OFFICER DELEGATED REPORT

Reference No.: 23/03120 **Cert of Lawfulness of Proposed Dev**
Proposal: Certificate of lawfulness to determine whether the proposed single storey detached garage is lawful.
Location: Bath Cottage Bath Road Littlewick Green Maidenhead SL6 3QR
Applicant: Mr And Mrs Werakso
Agent: Mrs Bronwen Gombert
Date Received: 15 December 2023
Case Officer: Aneesah Iftikhar
Recommendation: Refuse
Parish/Ward: White Waltham Parish Hurley And Walthams

01 PROPOSED SITE PLAN AND GARAGE FLOOR PLAN

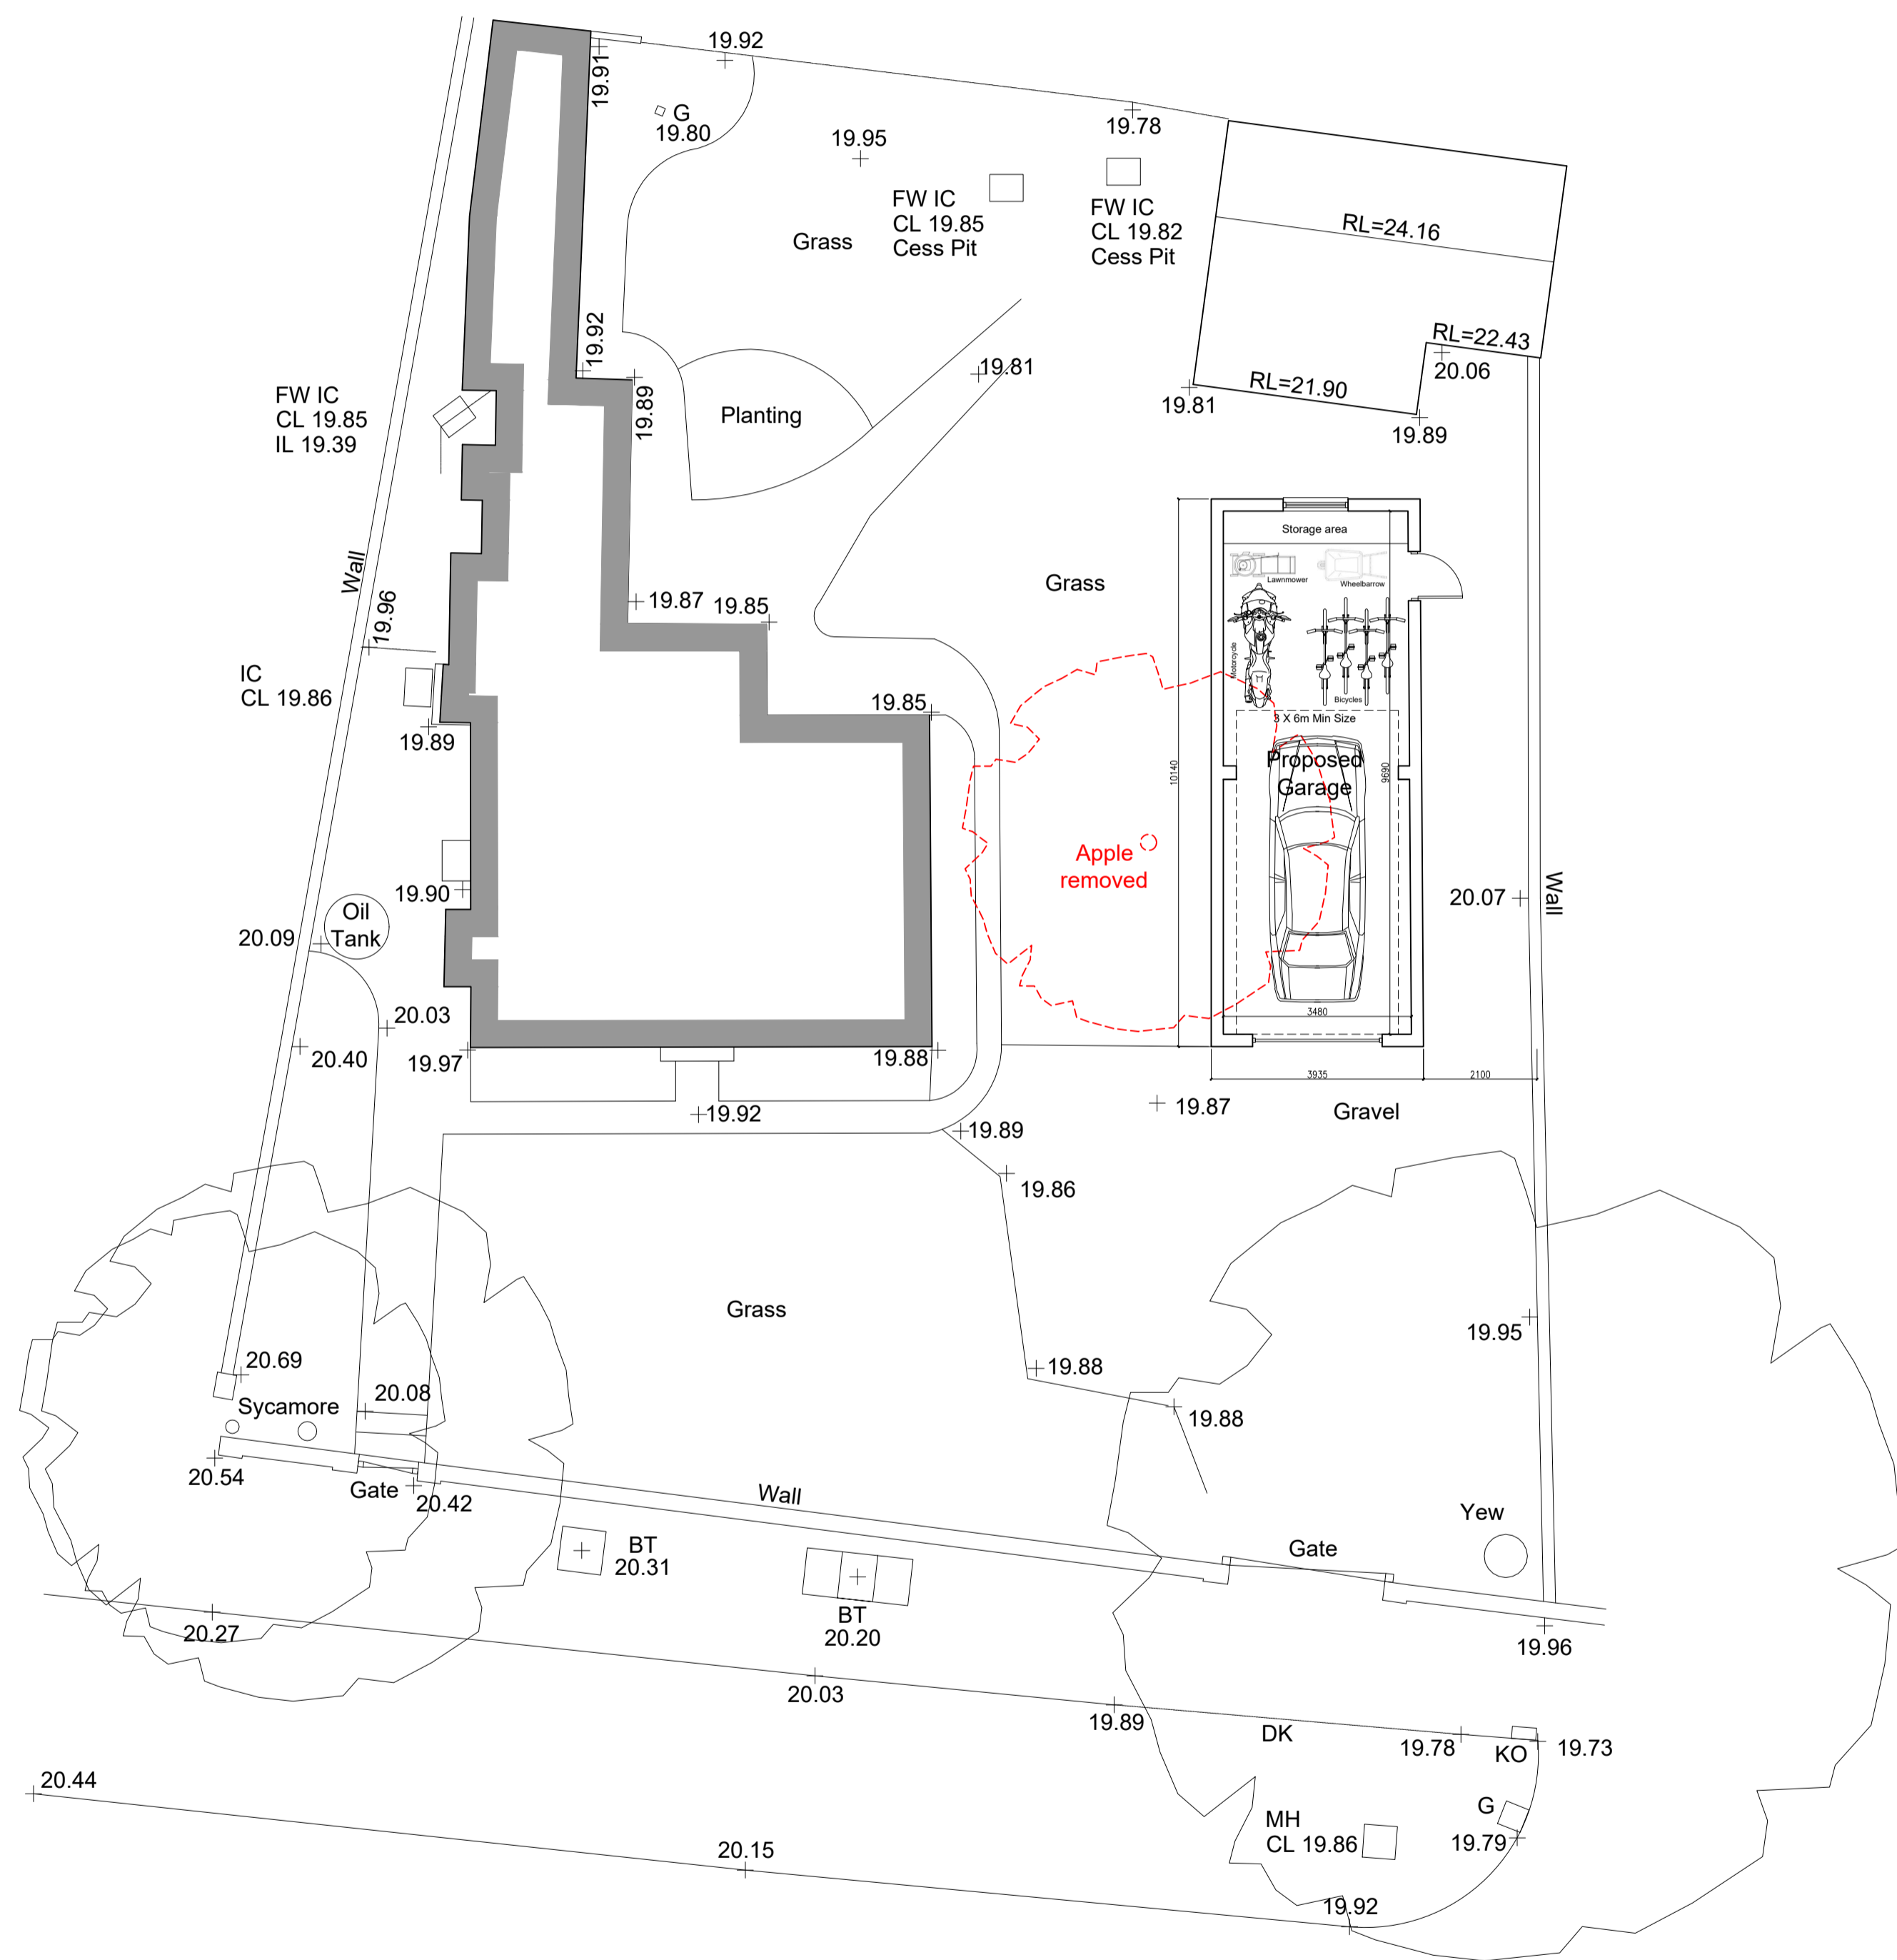
In terms of whether an outbuilding of the size proposed is reasonably necessary for the stated purpose, the outbuilding would measure approximately 10.14 metres by approximately 3.94 metres, which gives circa 39.9 square metres of internal floorspace for a garage. The size of the proposed outbuilding is not considered subordinate in relation to the footprint of the dwellinghouse and cannot be justified as reasonably required for the use proposed. The building would fail to be incidental to the enjoyment of the dwellinghouse by virtue of the size (in particular excessive depth) and use of the proposed outbuilding.

- 2 By virtue of its overall proposed size, the outbuilding is not considered to be reasonably required for the purpose(s) of being incidental to the enjoyment of the dwelling house. The proposed size of the building would be larger than would be reasonably required to serve the dwellinghouse for any incidental purposes. As such it would not be permitted development by virtue of Schedule 2, Part 1, Class E of the Town and Country Planning (General Permitted Development) Order 2015 (as amended). Planning permission is therefore required.

02 PROPOSED GARAGE ELEVATIONS

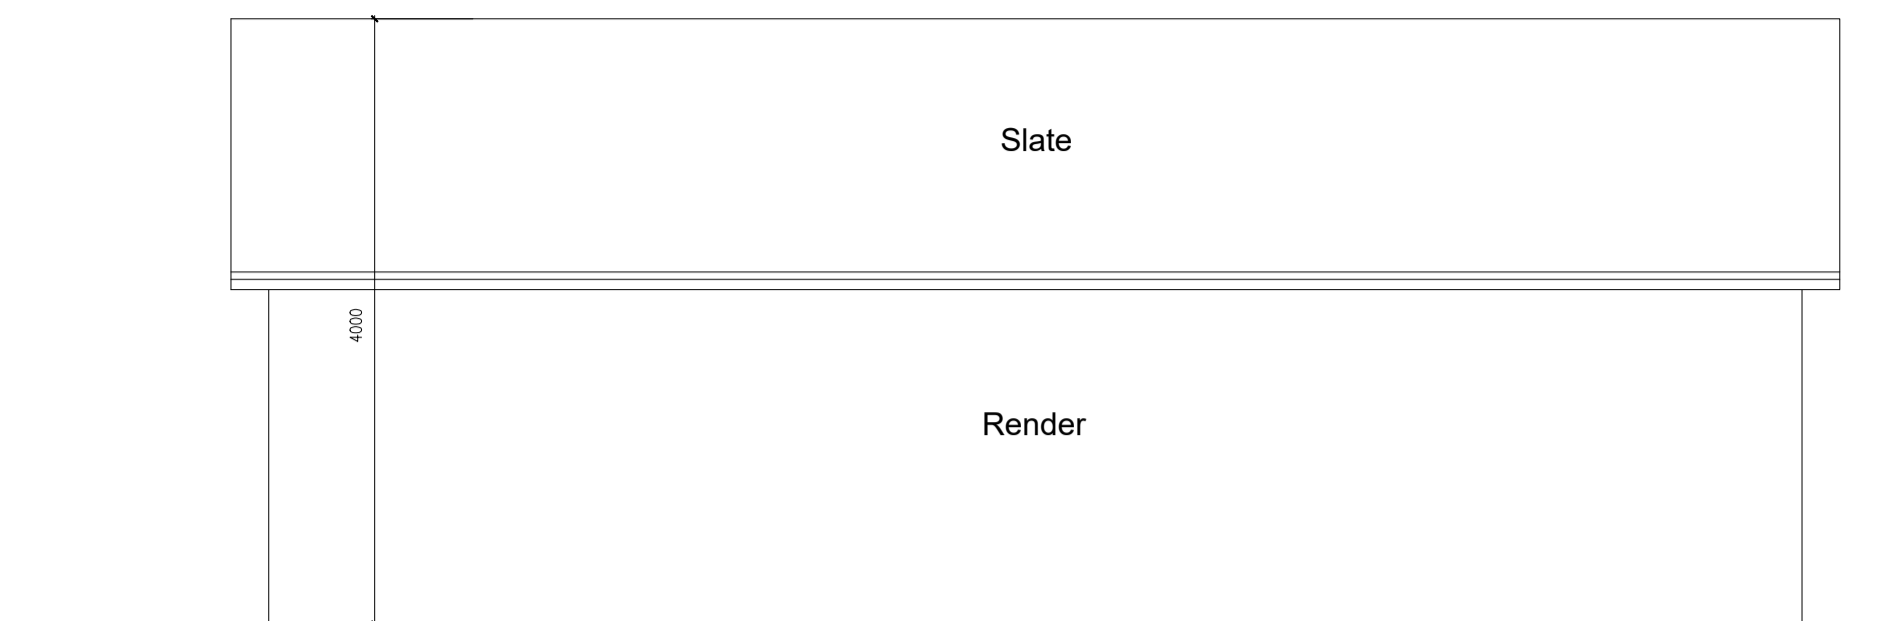
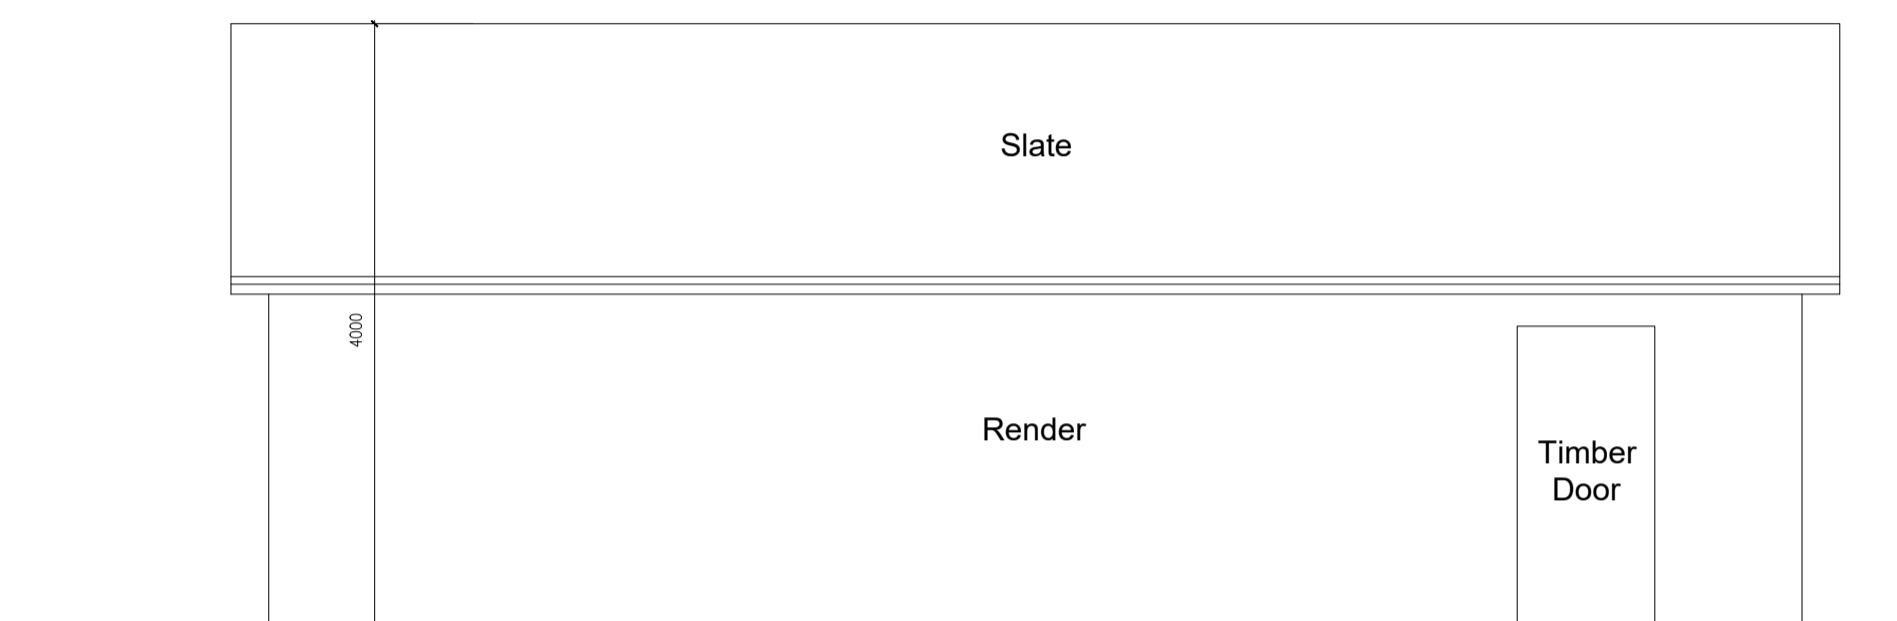
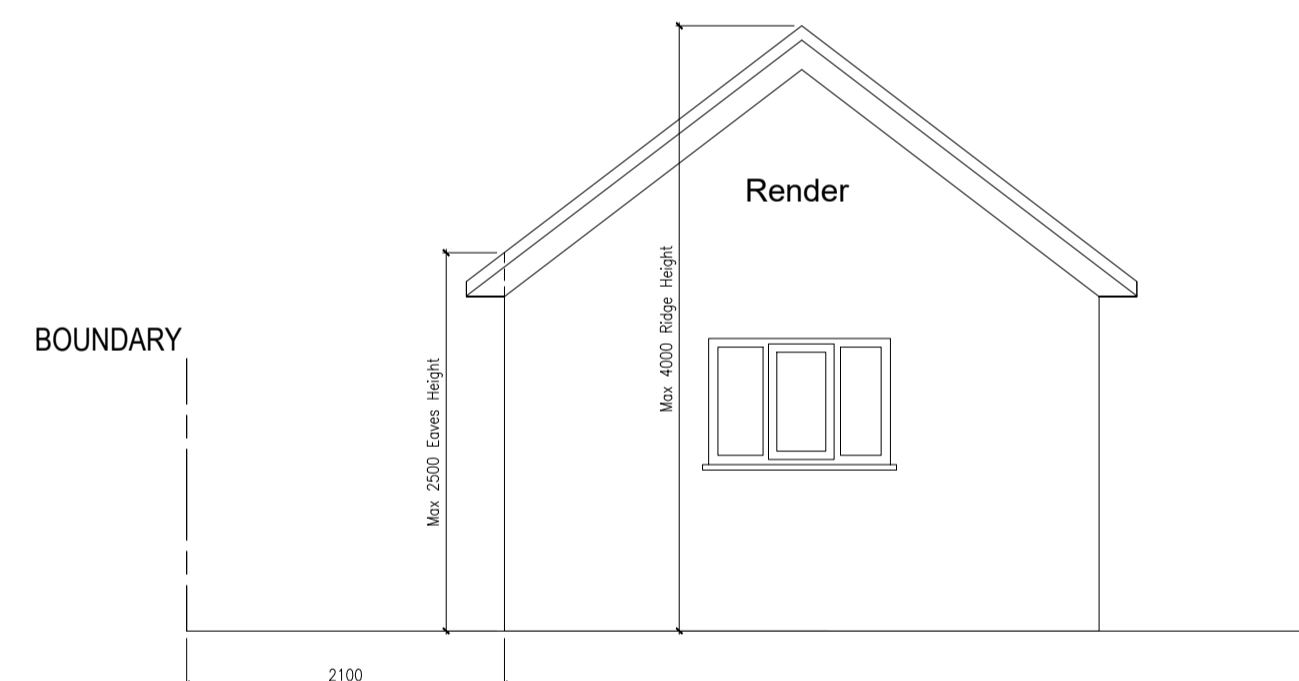
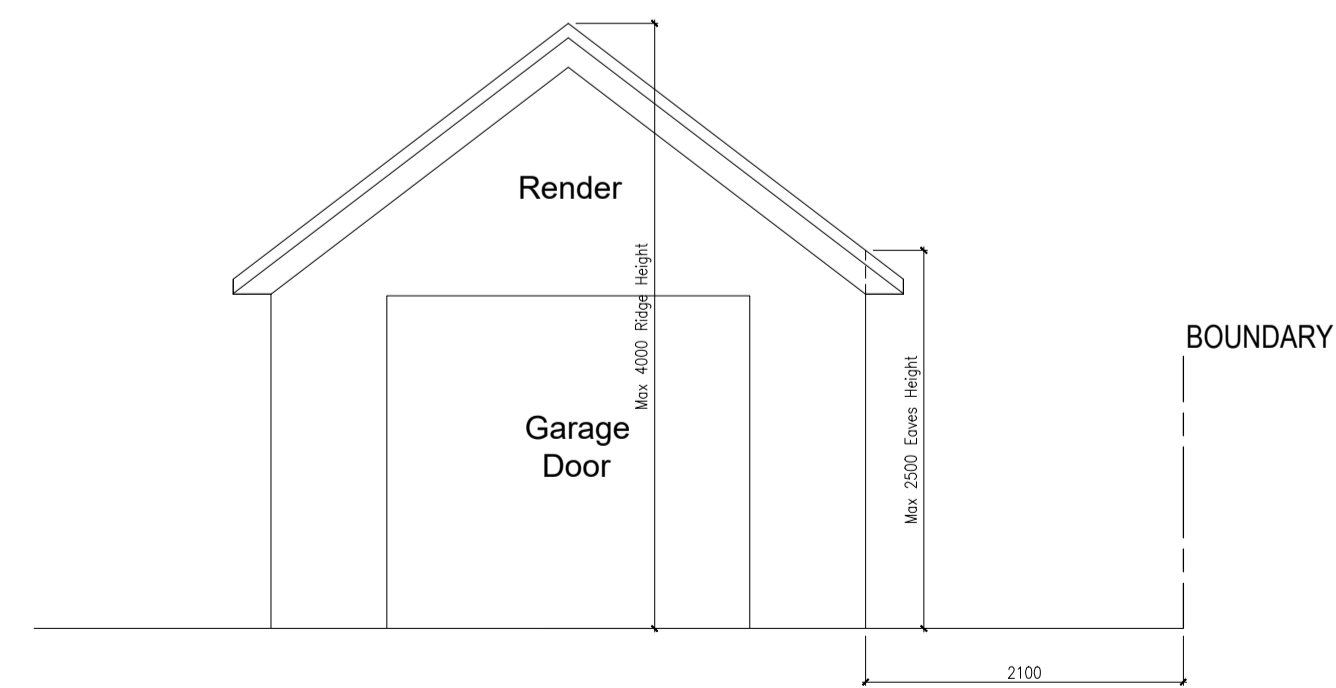
The height of the eaves of the building **would** exceed 2.5 metres (approx. 2.67m). According to the 'Permitted development rights for householders technical guidance', eaves height is measured from ground level at the base of the outside wall to the point where that wall would meet the upper surface of the roof slope. **The proposal fails to comply.**

- 1 The proposal is not automatically granted planning permission under Article 3 and Schedule 2, Part 1, Class E of the Town and Country Planning (General Permitted Development) Order 2015 (as amended). The proposal fails to comply with paragraph (f) as the proposed outbuilding would have an eaves height which exceeds 2.5 metres. Planning permission is therefore required.
